Copper Chase at Sterling Ranch
Traffic Technical Memorandum
PUDSP-22-002 ¹ 
(LSC #184990)
May 26, 2022

LSC Responses to TIS Redline Comments

Figure 4
School Pedestrian Routes
 Copper Chase at Sterling Ranch (LSC #184990)

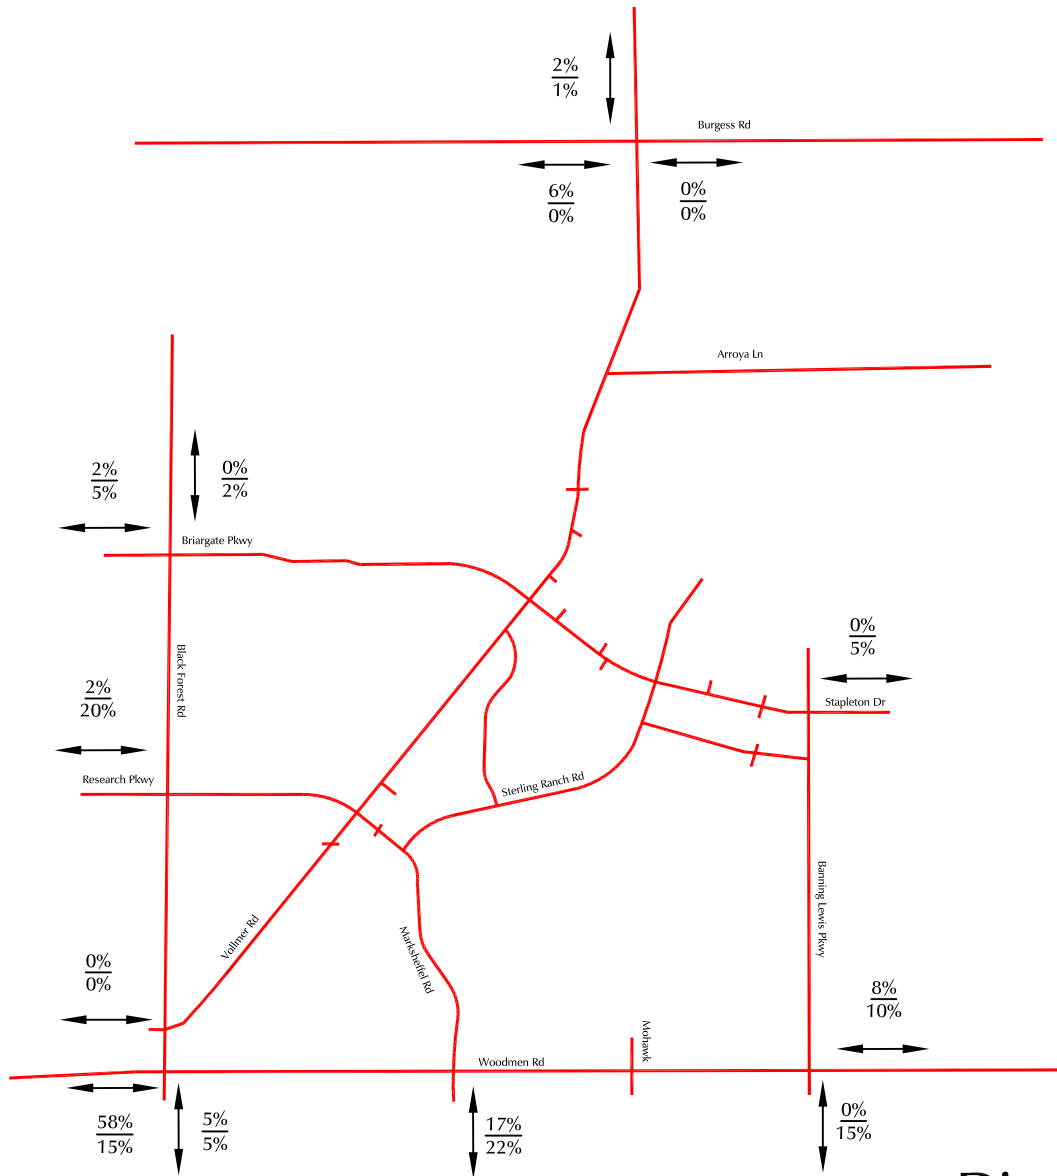
Number: 1 Author: CDurham Subject: Text Box Date: 11/8/2022 18:43:52 -07'00'

[Include street names](#)

LSC Response: Added as requested. Note: this Figure has been modified in the updated TIS.
